Our ref: OR-0001976
Your ref: EN010153
Date: 15 April 2026

ENVIRONMENT AGENCY DEADLINE 6 RESPONSE.

FRODSHAM SOLAR PROJECT, FRODSHAM MARSHES

April 2025

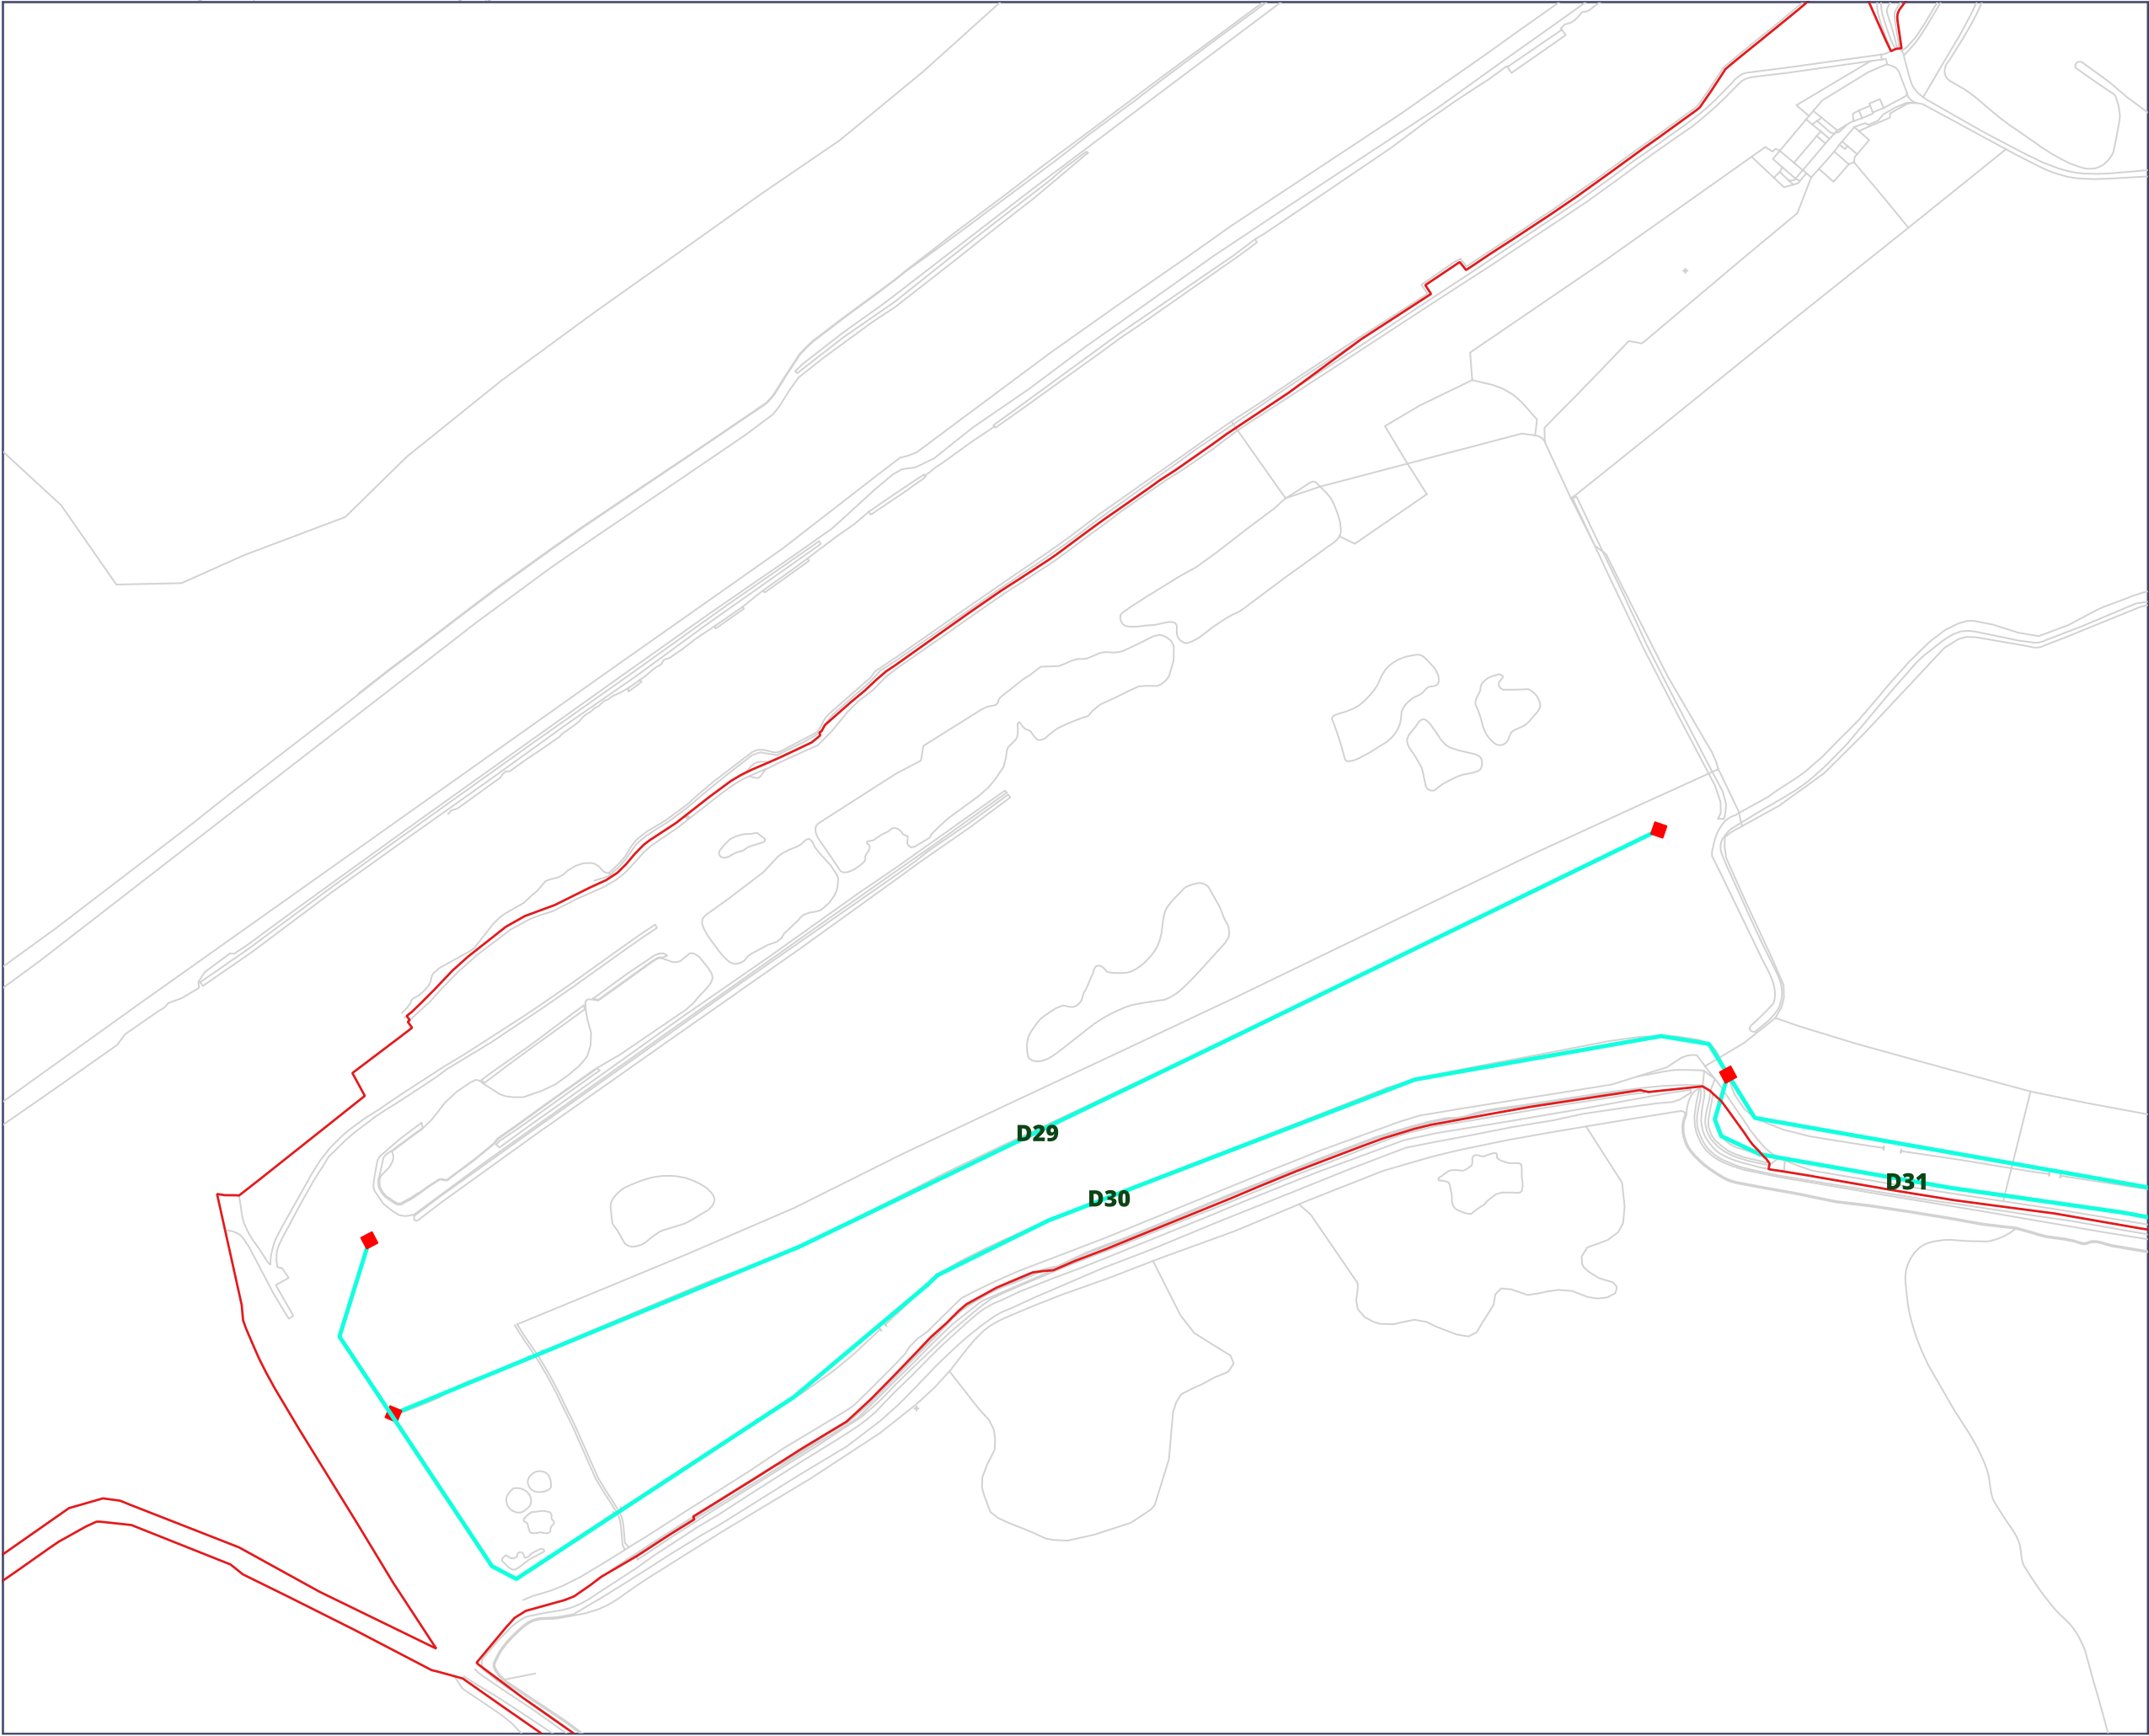
Our issue concerned the crossing design CP22, as it did not provide appropriate 300mm freeboard above the design flood event (1% AEP plus 67% CC - higher central allowance). We are content with the crossing designs for CP14 and CP17.

Outside of the examination, the Applicant has engaged with us to resolve this outstanding issue for CP22. The Applicant has proposed an alternative CP22 crossing design with supporting information for our approval (ref.14740-WCD-XX-XX-SK-S-006 P02, dated 23 March 2026). This design includes a raised crossing providing a 300mm freeboard from the base of the bridge steels to the in-channel flood level (flood level of 4.76m Above Ordnance Datum). They have also demonstrated that the raised road levels will not increase flood risk elsewhere.

The alternative bridge design and supporting information provided is sufficient to resolve our concerns regarding issue EA007. We are therefore content to agree this issue as resolved, subject to the submission of the alternative CP22 bridge design and supporting documentation at Deadline 6.
